2025/93532 Bromley Farm Quarry, Barnsley Road, Upper Cumberworth, Huddersfield, HD8 8PD

Discharge of details reserved by conditions 6 (site preparation and clearance), 8 (BEMP), 9 (landscaping), 11 (fencing), 12 (WSI), 14 (shared access), 16 (access road), 19 (wheel bath), 22 (Access Management Plan), 23 (parking), 49 (surface water discharge), 59 (delivery HGV route) on previous permission 2023/91280 for quarrying operations for the extraction of clay, shale and incidental coal and subsequent restoration by means of importation of inert wastes

WYAAS Ref: CWY603

Thank you for the email of the 23rd December 2025. Regarding the discharge of **Condition 12** at the above site.

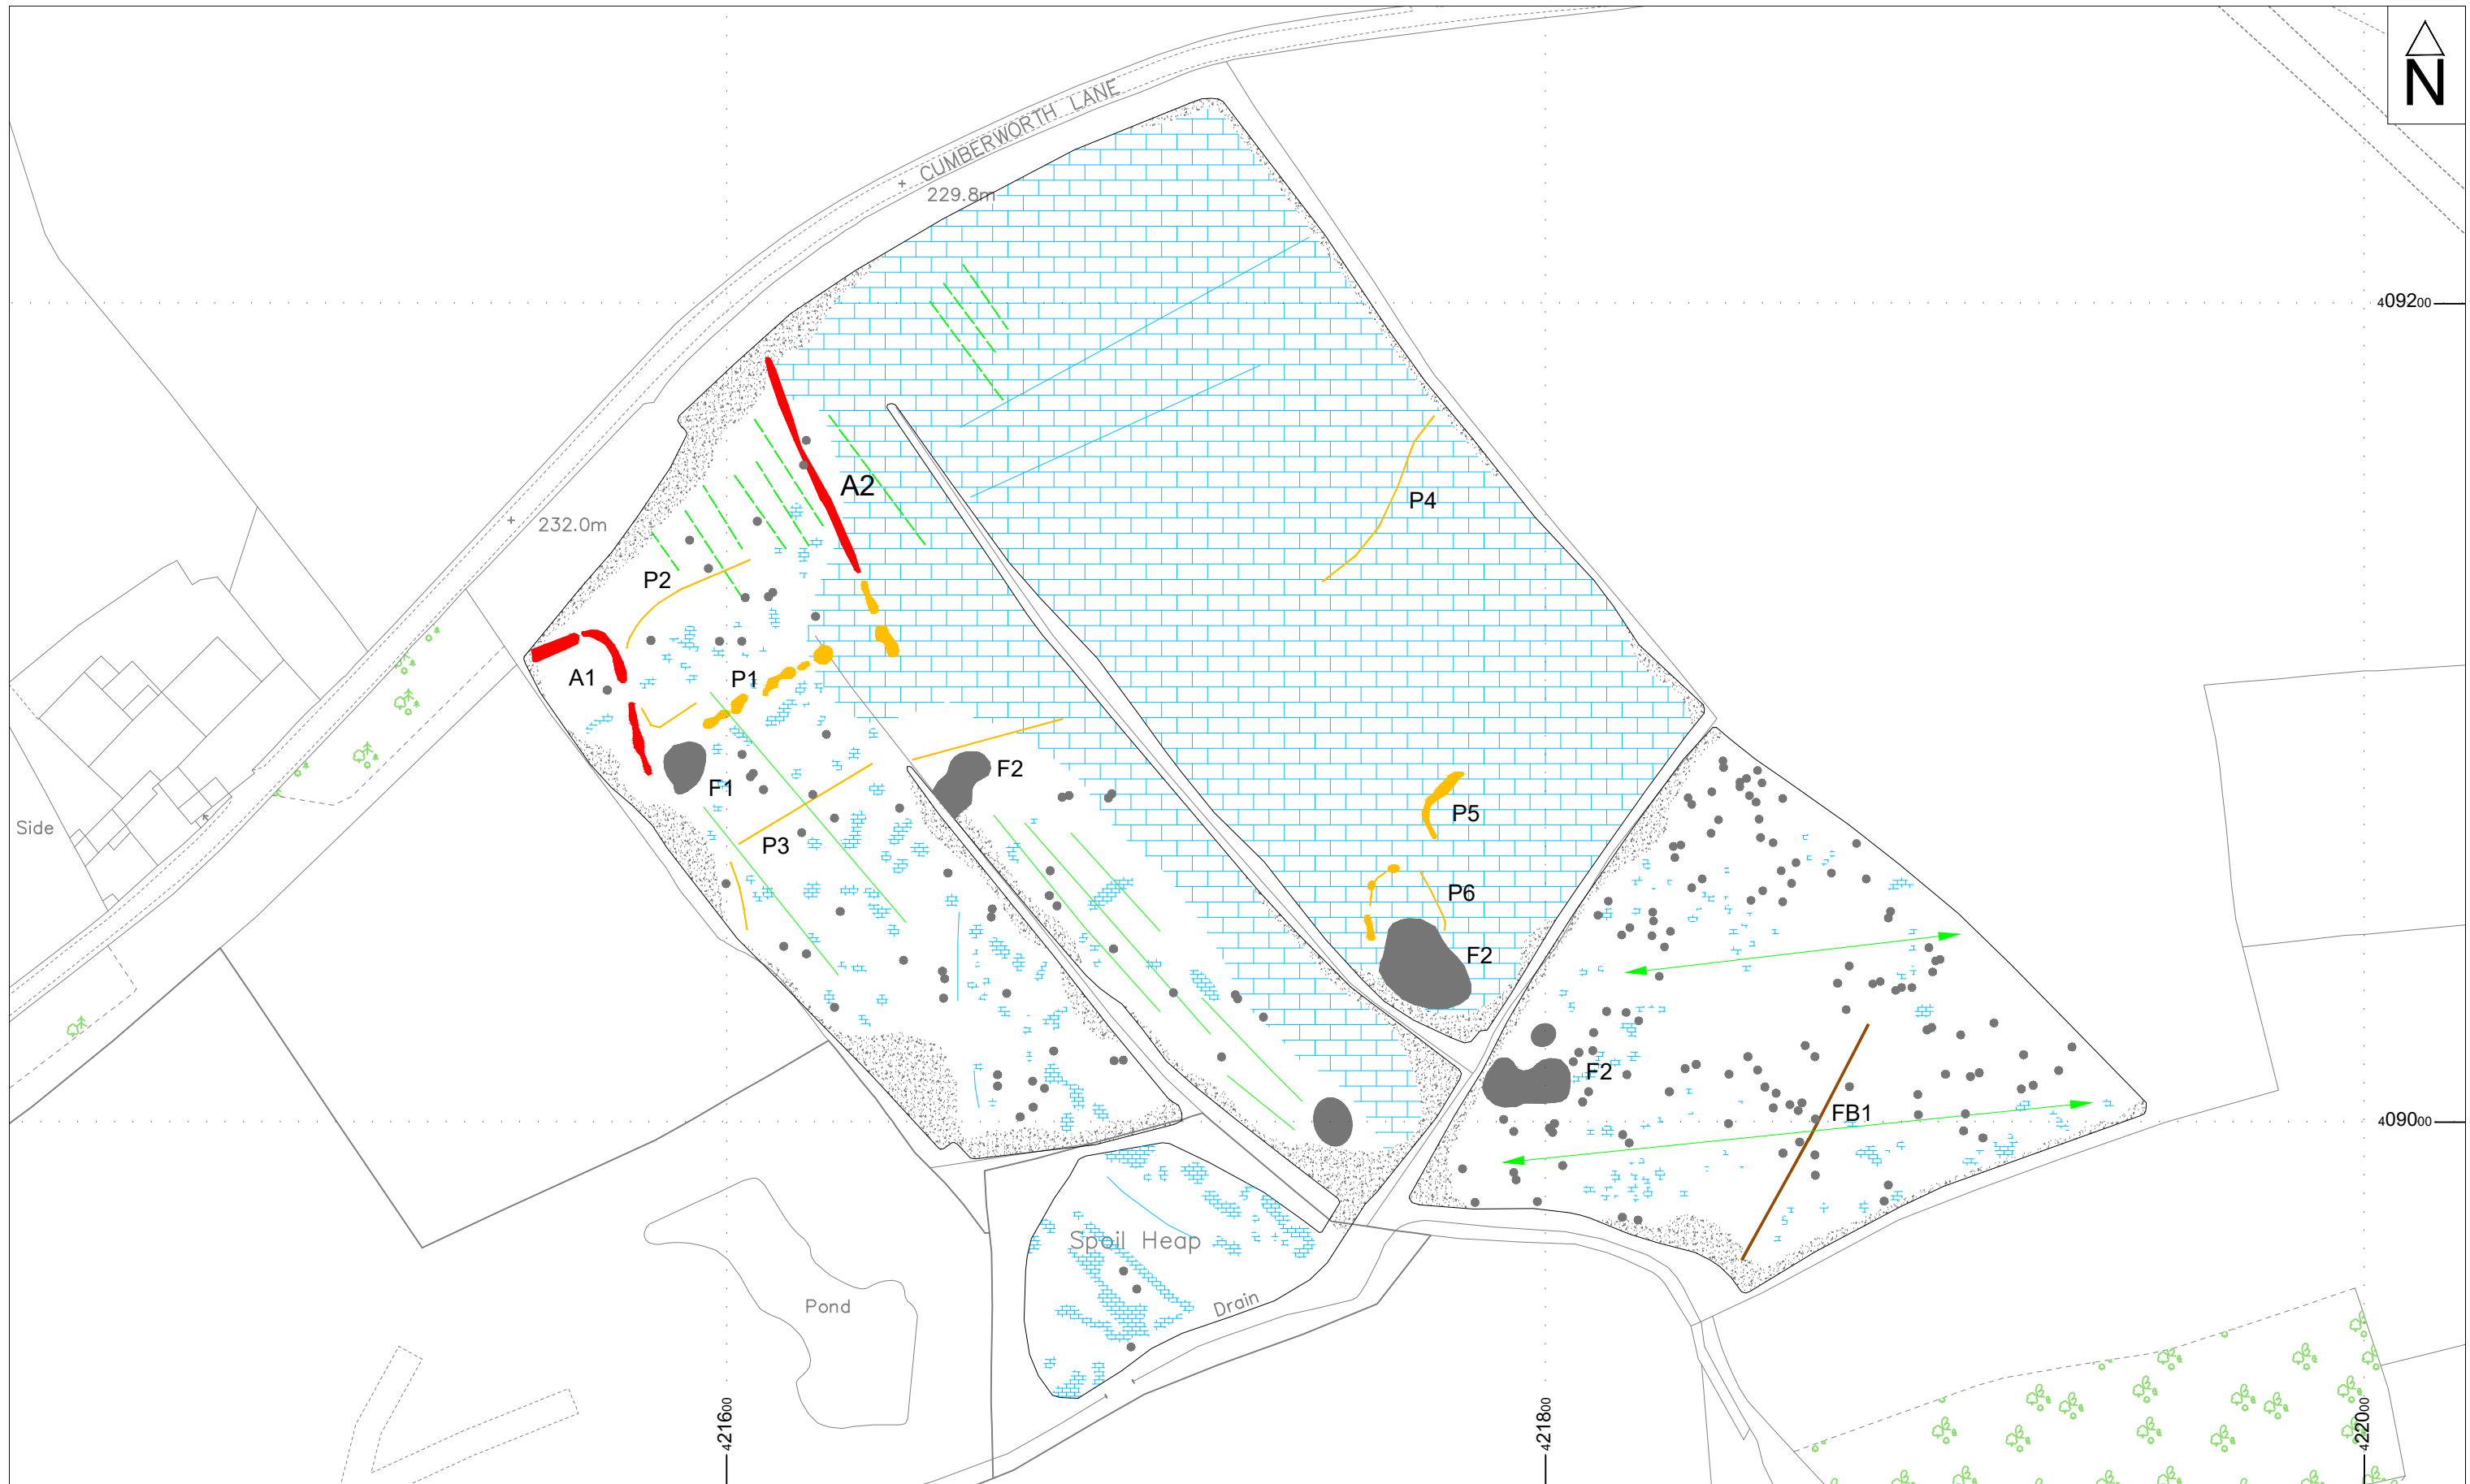
The report states that the Site is deemed to have a high archaeological potential, particularly in the northwest. The survey has detected magnetic anomalies of both a definite and a possible archaeological origin, including part of an enclosure and other ditch responses. Other anomalies have been highlighted as possible archaeological features.

Medieval or post-medieval ridge and furrow cultivation has also been detected, along with a former field boundary and modern ploughing. Geological responses can be seen throughout and are strong and widespread in places. Areas of the site are also noted to have an unknown potential due to the possible masking of features by this geology.

While the geophysical survey has successfully identified areas of potential interest, it identifies anomalies that require testing to fully understand their significance. Furthermore, the potential masking effect of the geology means that "blank" areas of the survey may still contain archaeological remains.

Consequently, the archaeological obligations required by Condition 12 have not yet been fully fulfilled. The purpose of the condition is to "establish potential archaeological interest," which currently requires further evaluation to verify the geophysical results.

Based on the high archaeological potential identified, WYAAS recommends that a programme of archaeological evaluation (Trial Trenching) is undertaken. This is necessary to:

1. Test the geophysical anomalies (including the enclosure and ditches).
2. Assess the archaeological potential of areas where geological masking may have occurred.
3. Confirm the presence, nature, date, and function of any surviving archaeological remains.

As the full programme of site investigation and recording has not yet been completed, WYAAS recommends that Condition 12 is not discharged at this time.

We advise that the condition remains in force until the trial trenching has been completed, the report submitted and approved, and any subsequent mitigation strategy agreed upon.
